MORGAN AND MORECAMBE OFFSHORE WIND FARMS: TRANSMISSION ASSETS

Annex 2.4 to Applicants' Response to Deadline 3 submissions from Statutory Consultees and other organisation: Lancashire County Council (REP3-084)

Document Numbers:
MRCNS-J3303-JVW-19135MOR001-
FLO-CON-CAG-RPT-0115
Document Reference: S_D4_2.4

**Figure 4.2: Designated sites (MCZ, SPA, SAC, Ramsar sites and SSSI) in the vicinity of the Transmission Assets offshore infrastructure search area**

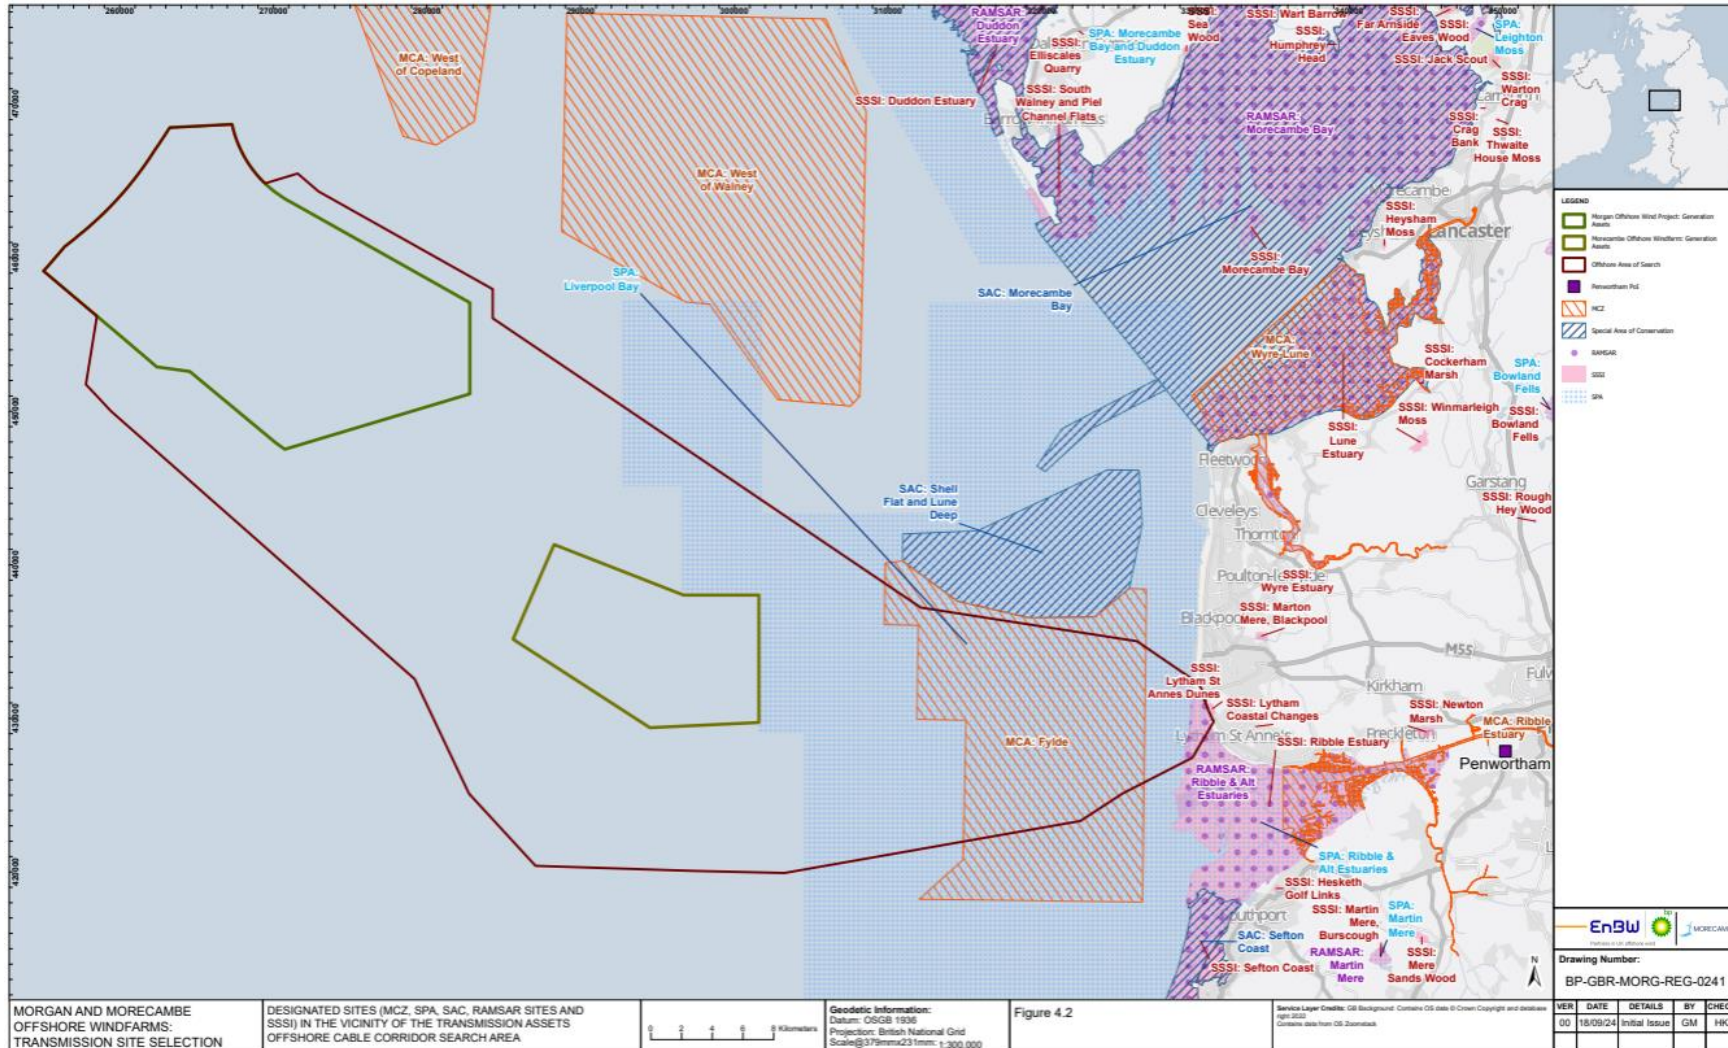
Reference	ExA Question	LCC Response	Applicants' response
	<p>shown on Figure 4.2. There is no evidence of the Green Belt being considered at this stage, noting that Table 4.7 [AS-028] which includes the Green Belt relates only to Stage 3c (refinement of onshore substation search areas for PEIR).</p> <p>...</p> <p>Taking account of any relevant policy and case law, to what extent does it need to be demonstrated that site locations outside of the Green Belt have been reasonably avoided?</p>	<p>However, it needs to be demonstrated that locations outside of the Green Belt have been considered and why they are unsuitable if that is the case. It is noted that only a relatively short section of the cable route lies within the Green Belt. The County Council considers that there is a lack of justification on this point which is a major omission.</p>	<p>This document sets out the reasons why the Green Belt entered into the site refinement process at Stage 3c, and clearly demonstrates (via an additional onshore constraints map) that the areas of Green Belt to be affected could not reasonably have been avoided without resulting in significant environmental impacts that are avoided by the choice of substation locations.</p> <p>As set out in the Green Belt Technical Note at paragraph 1.6.4.21, the Applicants agree that the substations would constitute inappropriate development.</p> <p>Notwithstanding the fact that the Transmission Assets comprise critical national priority infrastructure, for which the starting point for decision making is the presumption that the test of very special circumstances is met, very special circumstances do exist which clearly outweigh any harm to be caused to the Green Belt, by reason of inappropriateness or any other identified harm. The very special circumstances which exist in relation to the Transmission Assets are set out in section 1.7 of the Green Belt Technical Report.</p>
